PLANNING CONSULTATION RESPONSE

Application No	2026/0535
Proposal	2026 0535 Erection of Extension to Existing Detached Garage Replace Flat with Pitched Playroom Roof Hudroyd House Genn Lane Ward Green
Address	Hudroyd House Genn Lane Ward Green
Date of Consultation Reply	130726
Consultee	Tony Wiles Senior Conservation Officer

Drawing
Previously approved & Proposed Plans, Elevations
& Block Plan

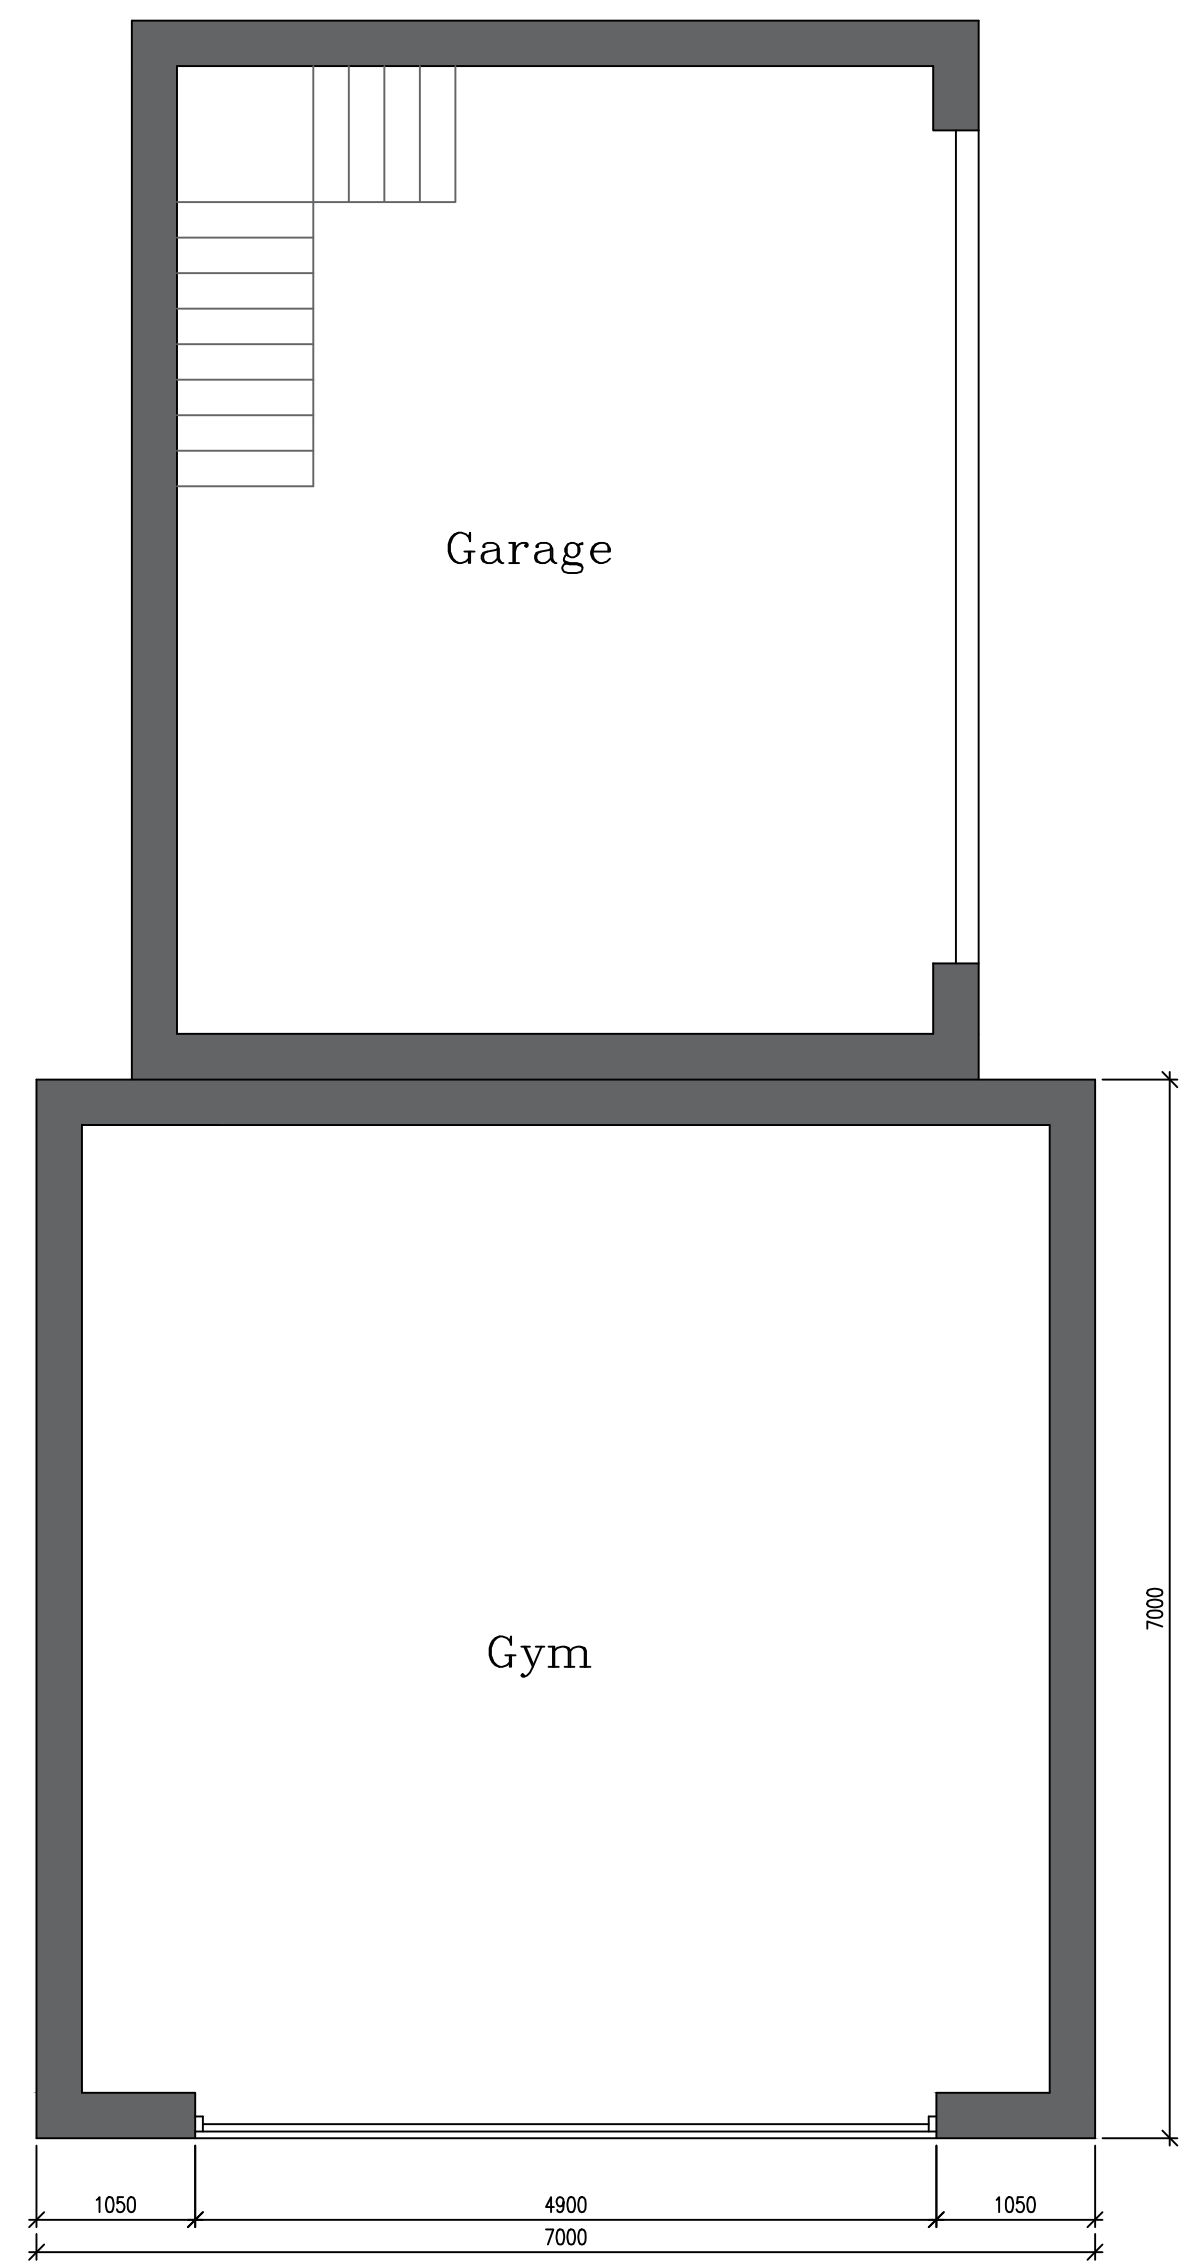
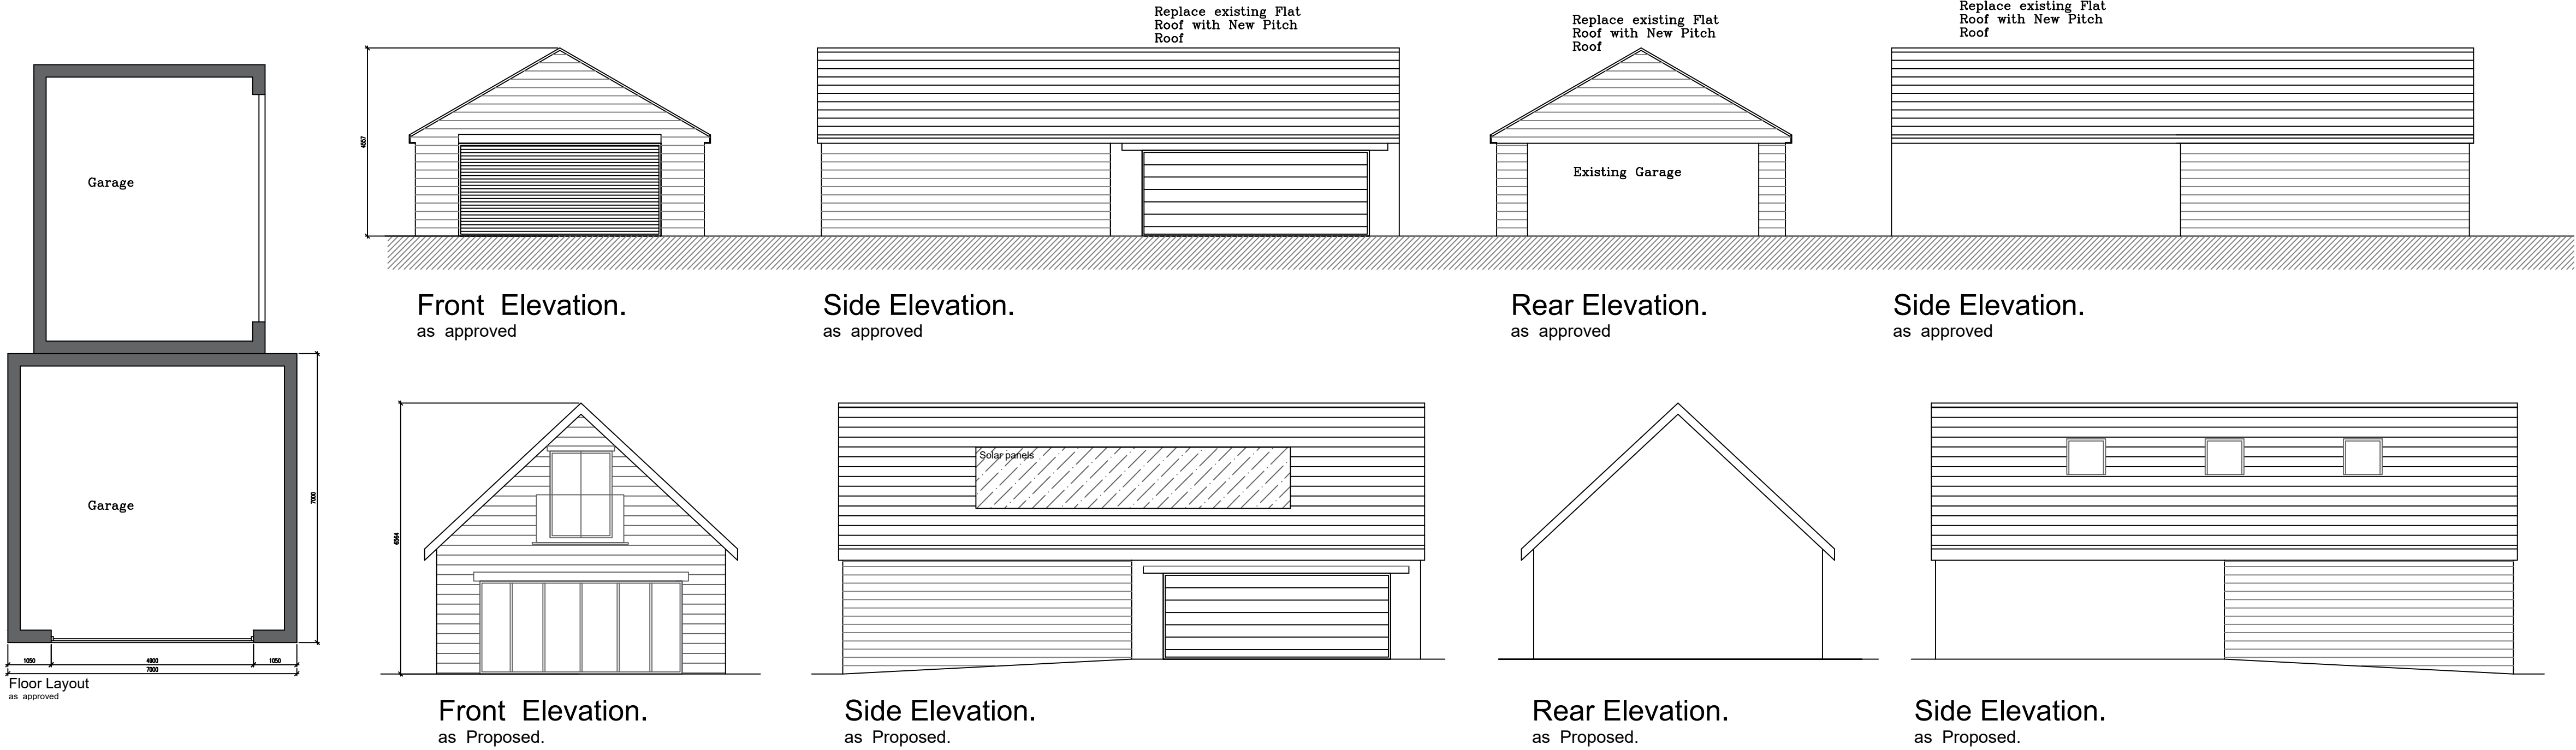
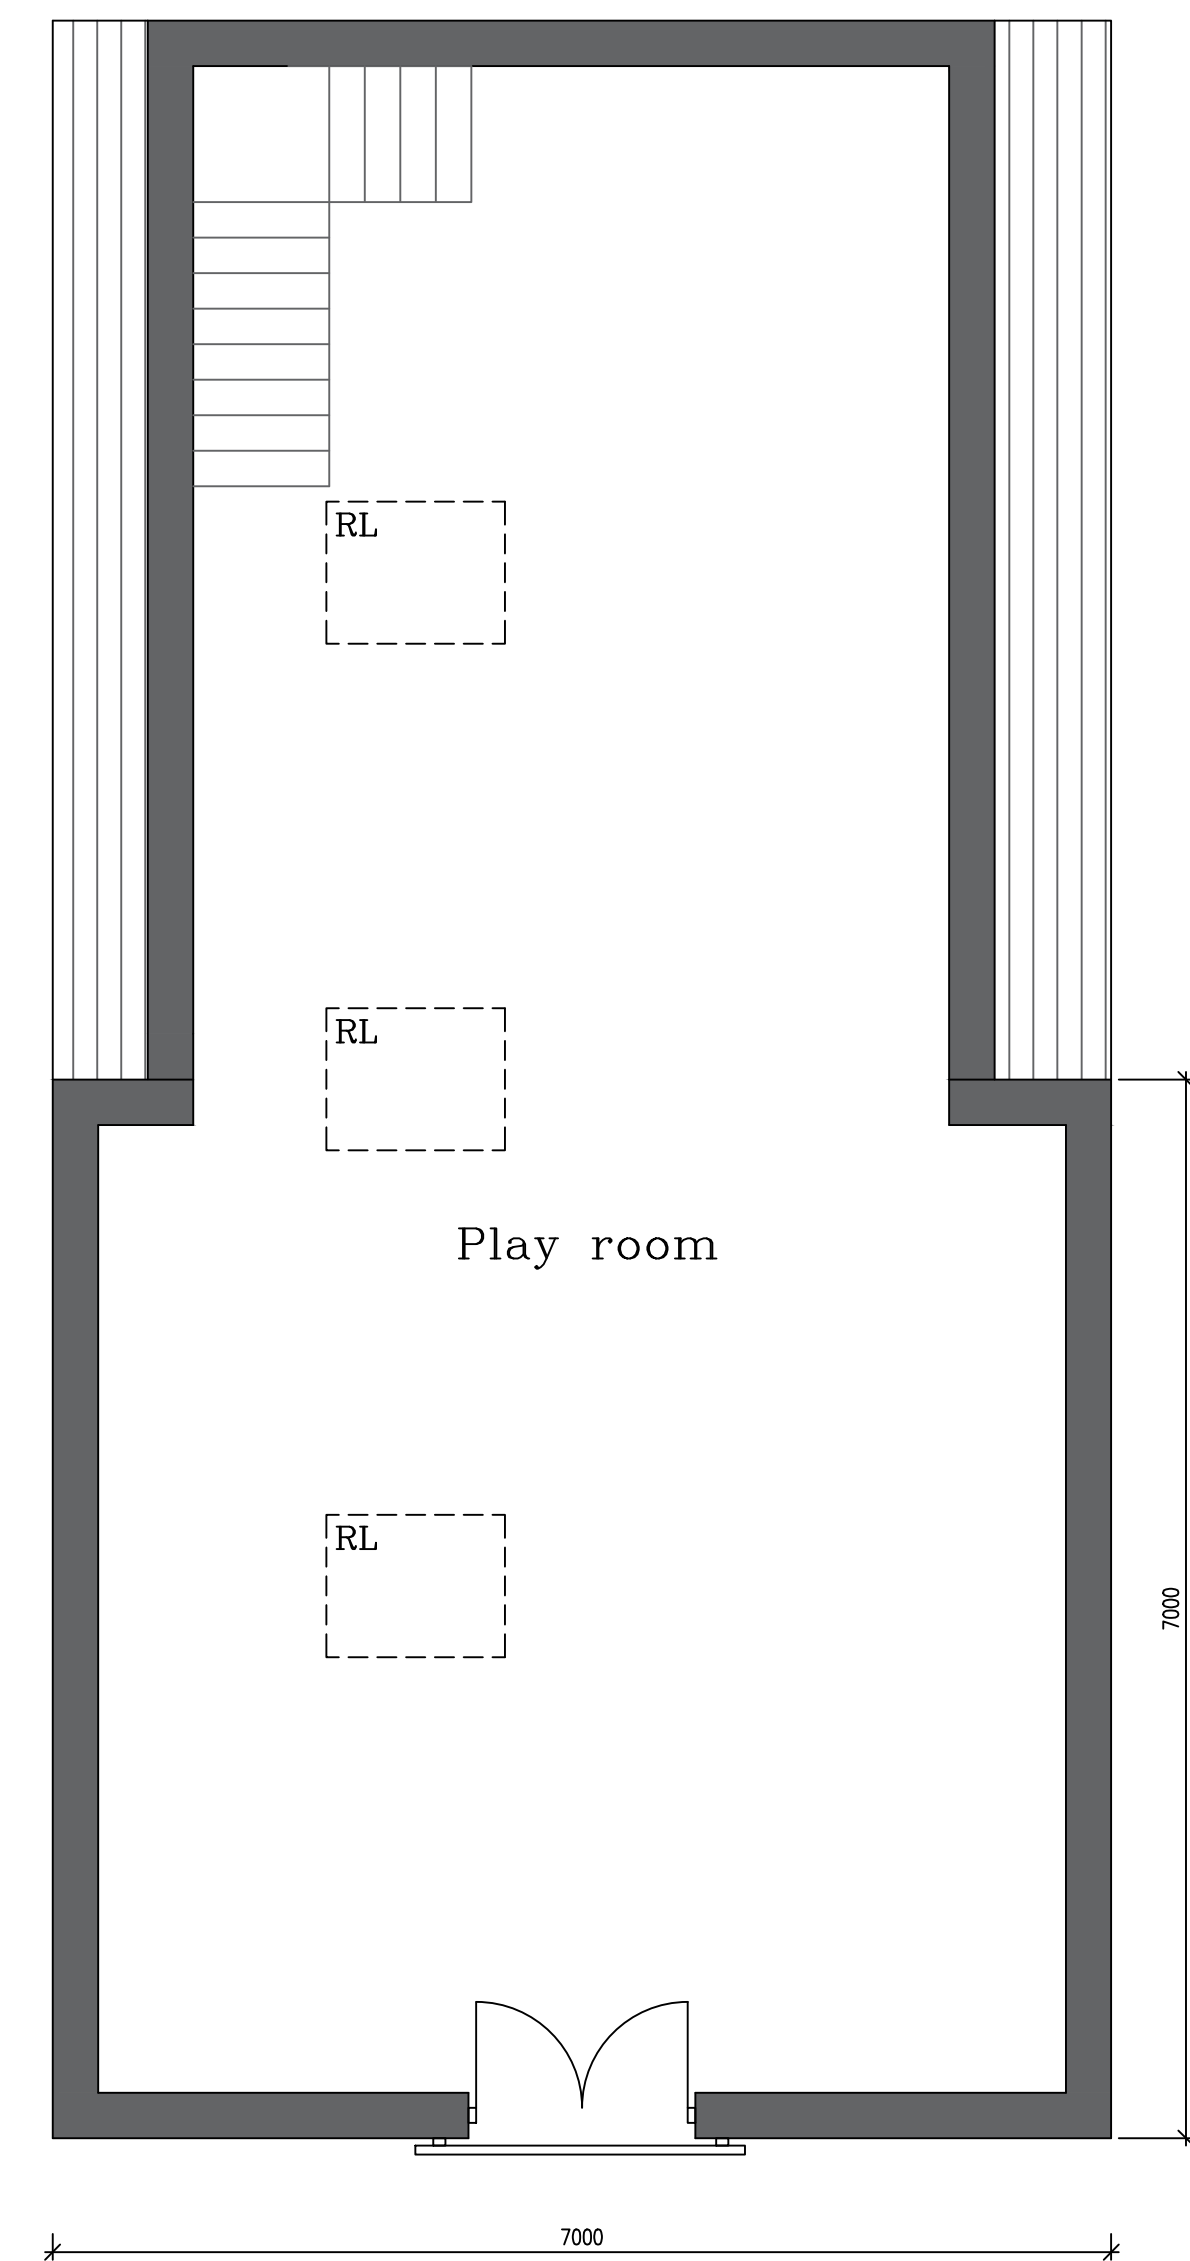
The materials used in the construction of the garage walls shall match those used in the construction of the existing garage including stone type, colour, face dressing and pointing detail

The roof shall be covered using either a natural stone roofing slate or blue/grey slates or good quality riven artificial alternative that emulates this closely and shall be laid in diminishing courses with matching ridge tiles

The rooflights used in the development shall be conservation specific rooflights, low in profile, vertically emphasised, with a single vertical divider, and decorated black.

The doors of the Juliet balcony in the southern gable shall utilise dark grey frames which shall be mounted a minimum of 100mm in the reveal. The glazed balustrade shall be affixed directly to the stonework using glass clamps or a similar unintrusive fixing method
